Moorebank Intermodal Precinct West – Concept Plan and Stage 1 Modification 2 (SSD-5066-Mod-2) and Stage 2 Modification 1 (SSD-7709-Mod-1) – Response to Submissions

Attachment 1 – Key Issues Raised:

2 PRECINCT PLAN - SSD 5066 MOD 2
- PROPOSED SCALE 1:5000 @ AD

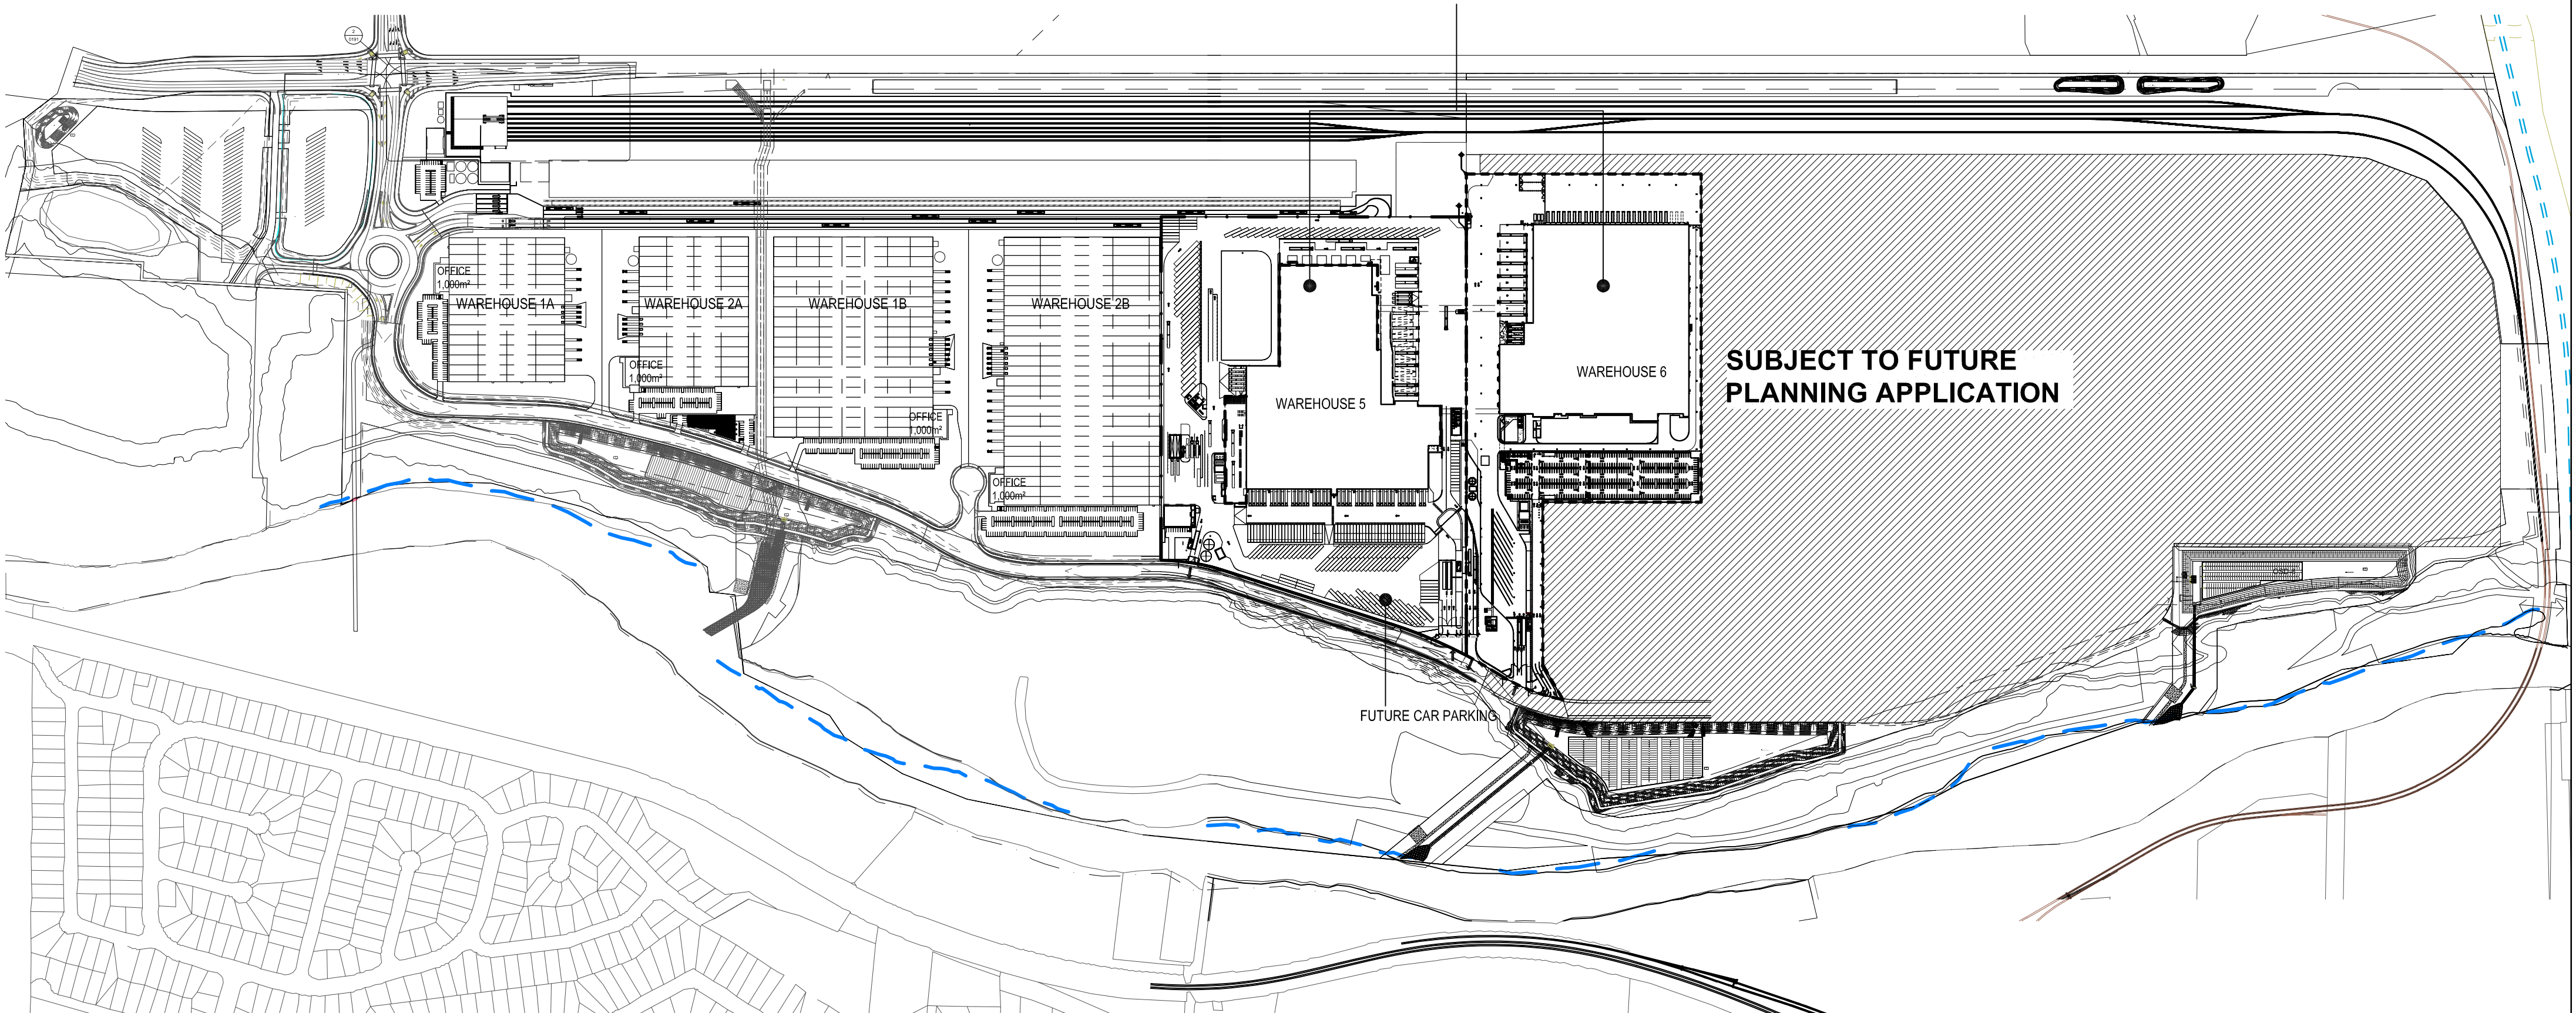
The proposed increase in building heights for warehouses 5 and 6 is a key concern raised during the exhibition of the modifications, which the Department requests you address. Additional information required to address these concerns should include, but not be limited to:

- Further justification of the proposed 45 m heights and subsequent non-compliance with the Liverpool LEP;
- Additional evidence to demonstrate that current approved warehouses height of up to 21 m would not be commercially viable (i.e. that the proposed height increase is required to ensure that the site is viable for future commercial operation);
